**PROPOSAL NAME:** Harrell & Sons Farm Accessory Dwelling Unit, AU-14-00003

**NAME OF DOCUMENT:** Notice of Application

RE: ***Harrell & Sons Farm Accessory Dwelling Unit - (AU-14-00003)***

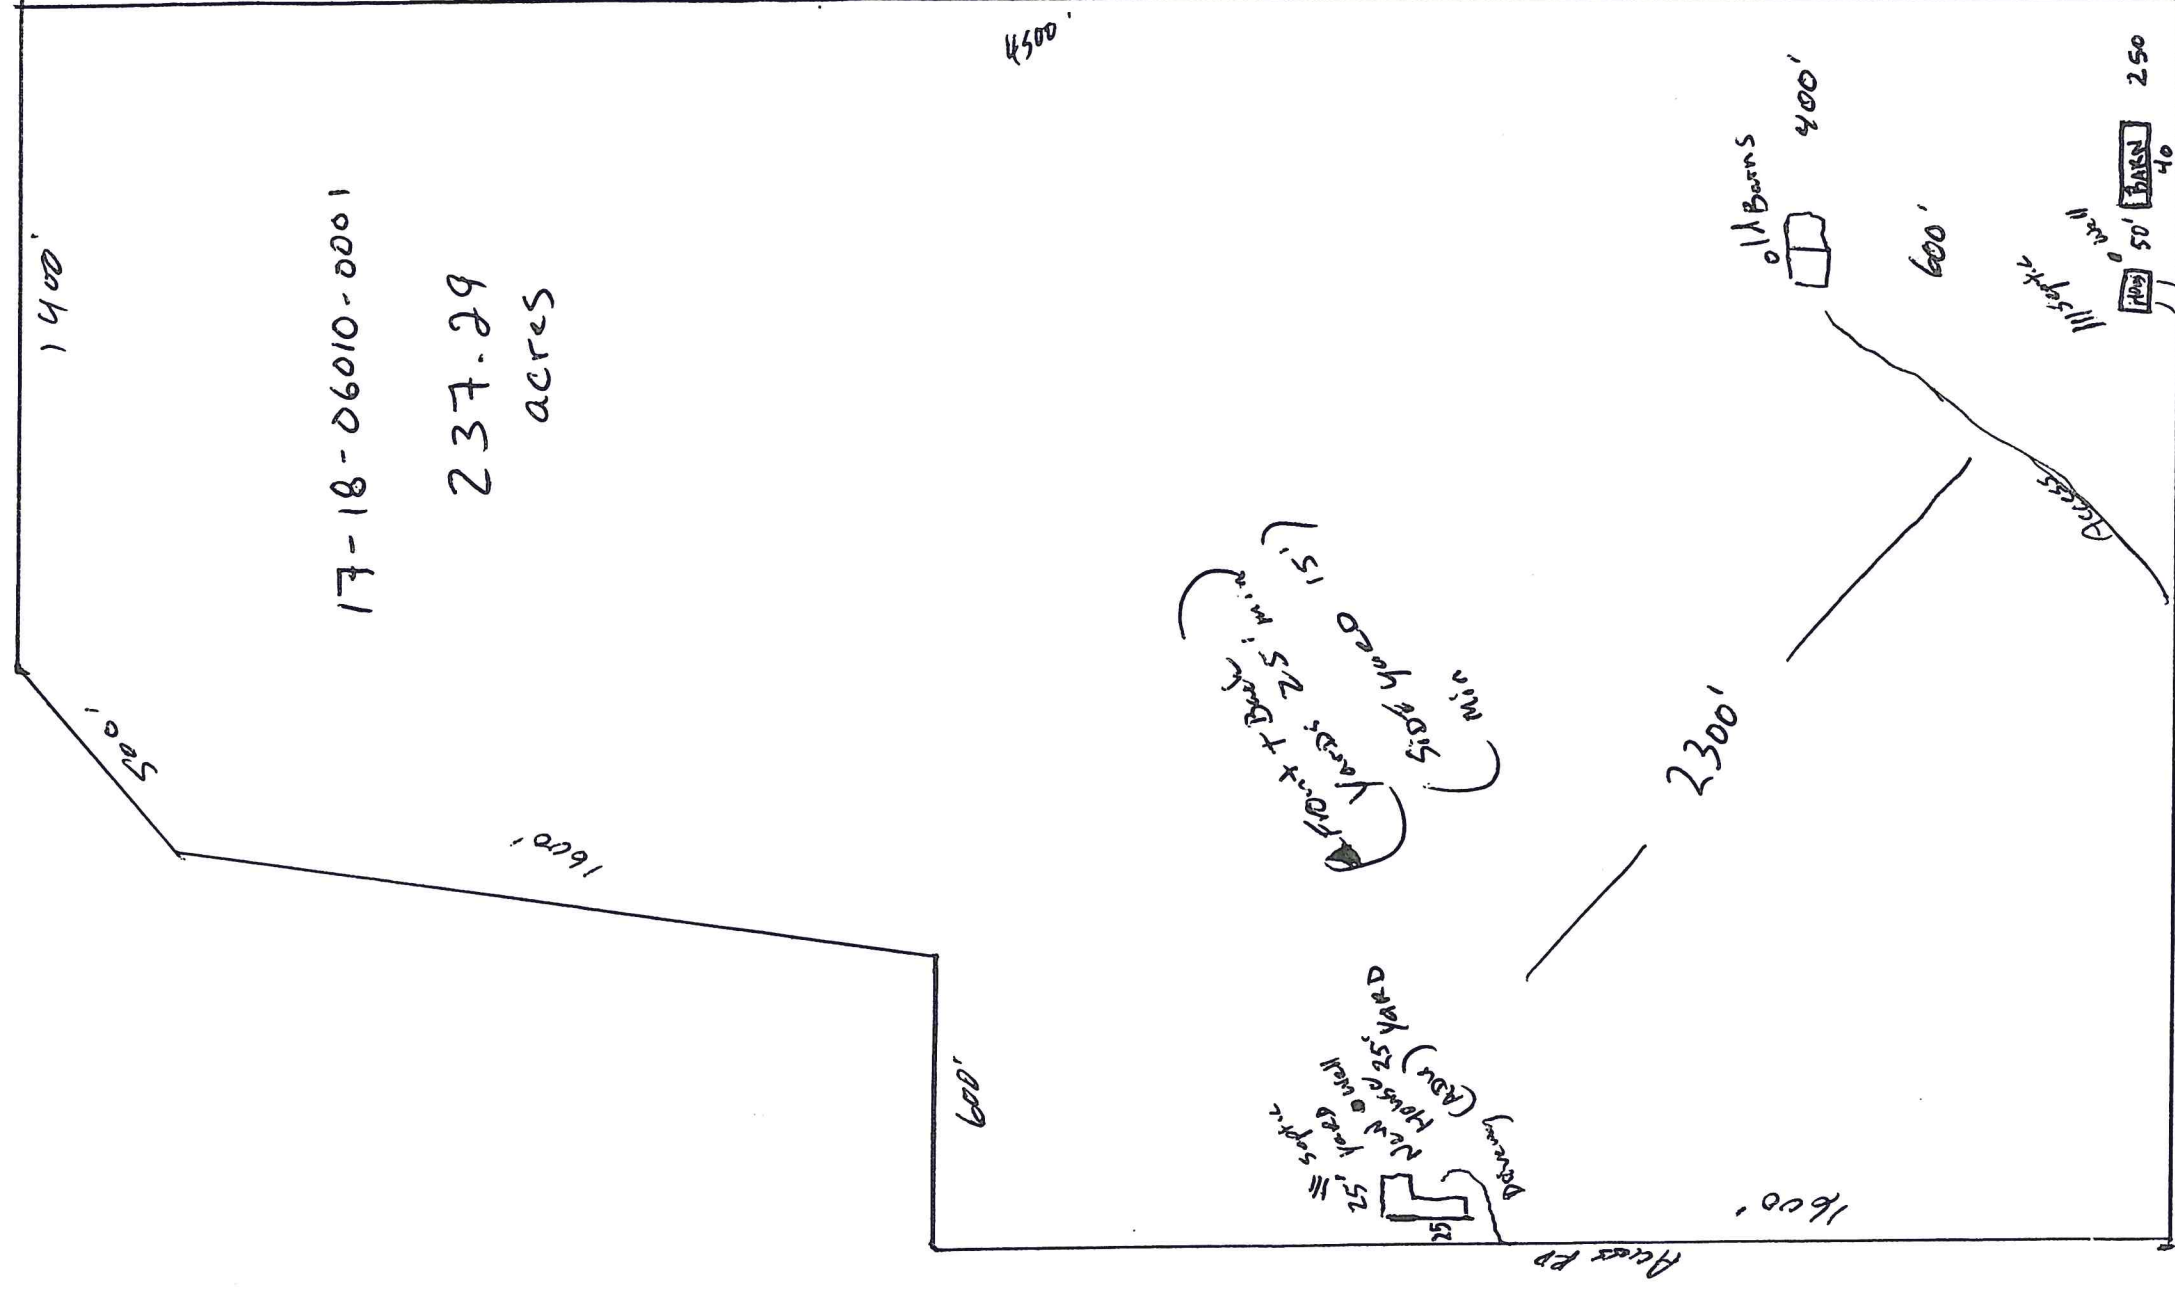
- K. The ADU is not located on a lot in which a Special Care Dwelling or an Accessory Living Quarter already exists.
- *A scaled site plan of the parcel depicting all existing & proposed structures, wells, drain fields, and access points/ roads.*
